**Addendum No. 2**

RE: Contract ID: C201371

**Richmond, Moore Counties (R-2502A, R-2502B)**

US-1 From South of SR-1001 (Marston Rd) To  
Existing 4-Lanes North of Moore County Line

APPROVED:	DATE: 10/10/08	TEMPORARY SHORING DATA AND TEMPORARY PAVEMENT MARKING SCHEDULE	
	SCALE: NONE		
	DATE: 02/08		
	DWG. BY: DAH		
	DESIGN BY: DAH		
REVIEWED BY: JWW	REVISIONS:

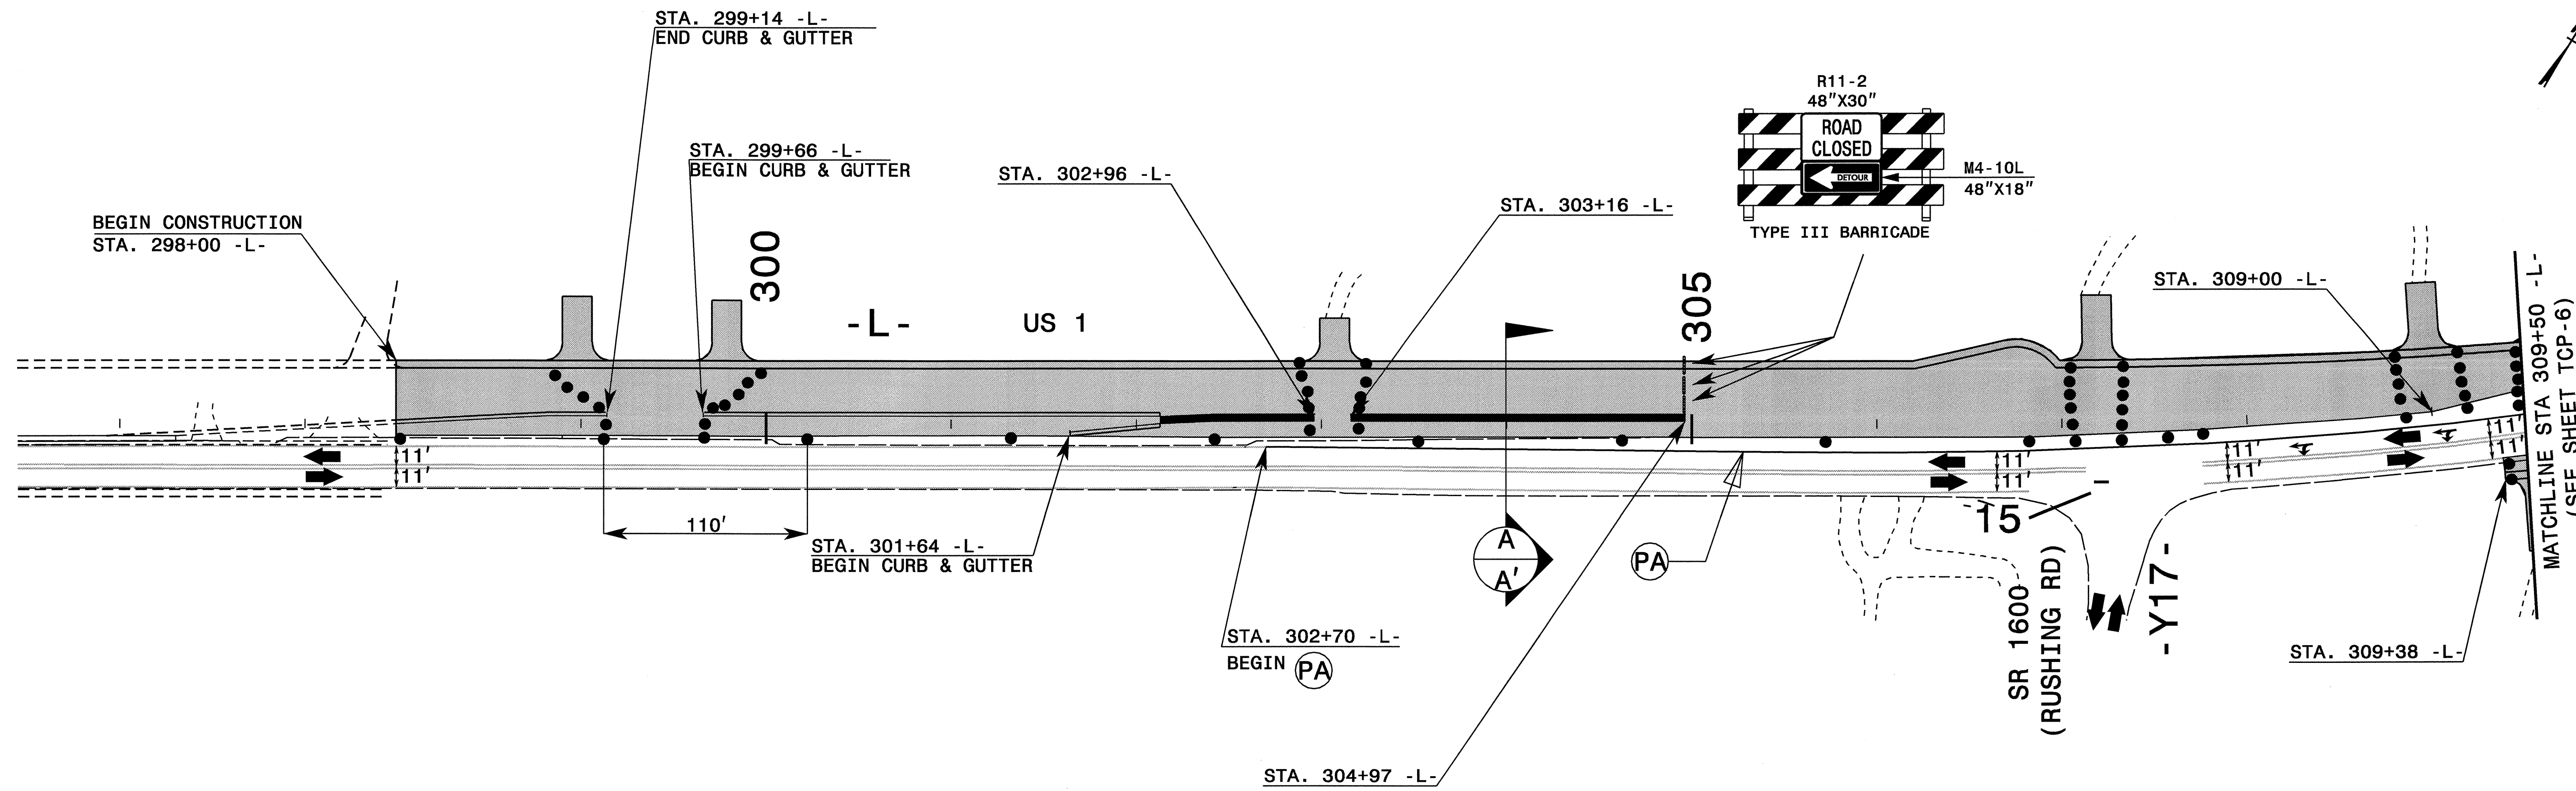
Sheet No. TCP-4 (for R-2502B) has been revised to correct "Temporary Shoring" stations. Please void Sheet No. TCP-4 in your plans and staple the revised Sheet No. TCP-4 thereto.
